Your Ref: OWPC3908
Our Ref: LU/265/14/HH 21-08-2014
Please ask for:
Mrs A Gardner

Enclosed porch to west elevation. This application may be determined by Littlehampton Town Council under delegated powers

59 Arundel Drive Thornlea Park Lyminster Road Littlehampton

proposed plan

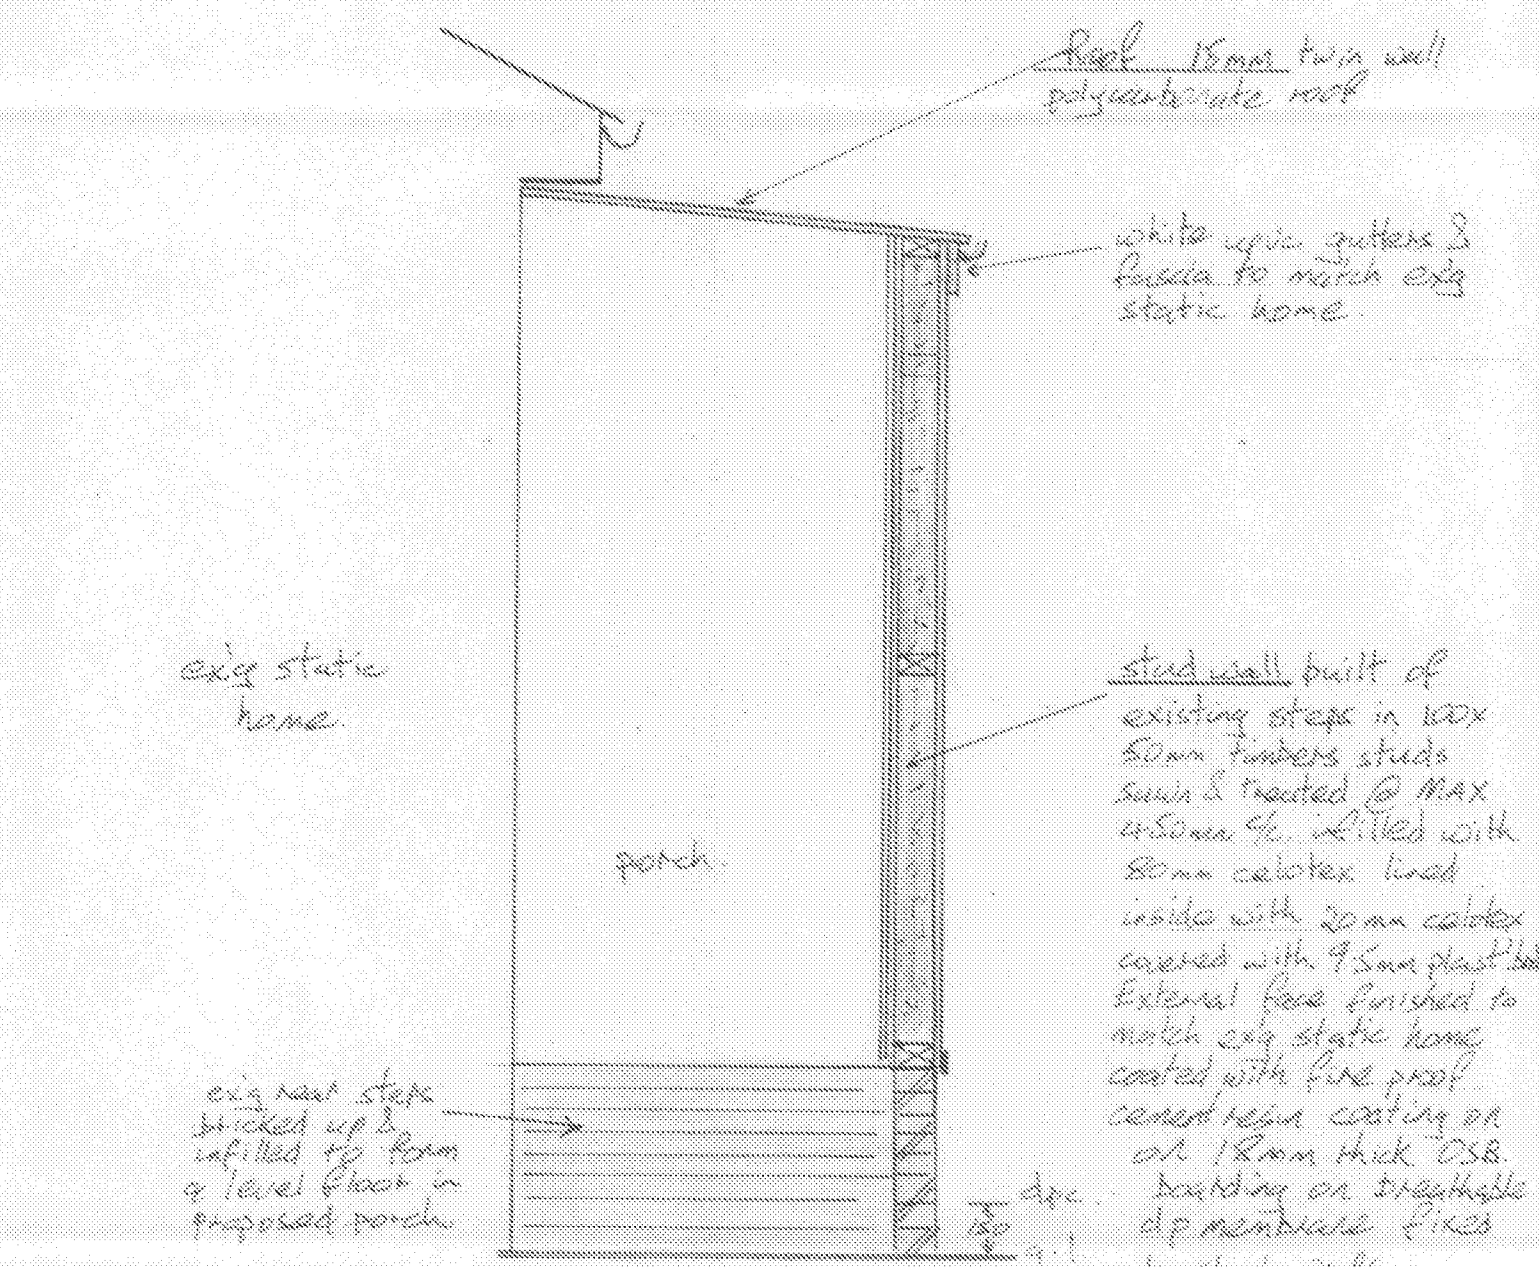
the existing steps appear to be not as wide as the proposed drawing states, which means that the steps will have to be widened to 1150cms as per the drawing, this will cut down the space for entry/access of the fire service should there be a fire, also the car on the parking space will cut down the gap between the perimeter fence and the proposed porch, also the car parking space is adjacent to another parking space, the park rules state that no two vehicles should be parked side by side in case of fire, because of this the entry is restricted to the fire service, these are my reasons for objection.
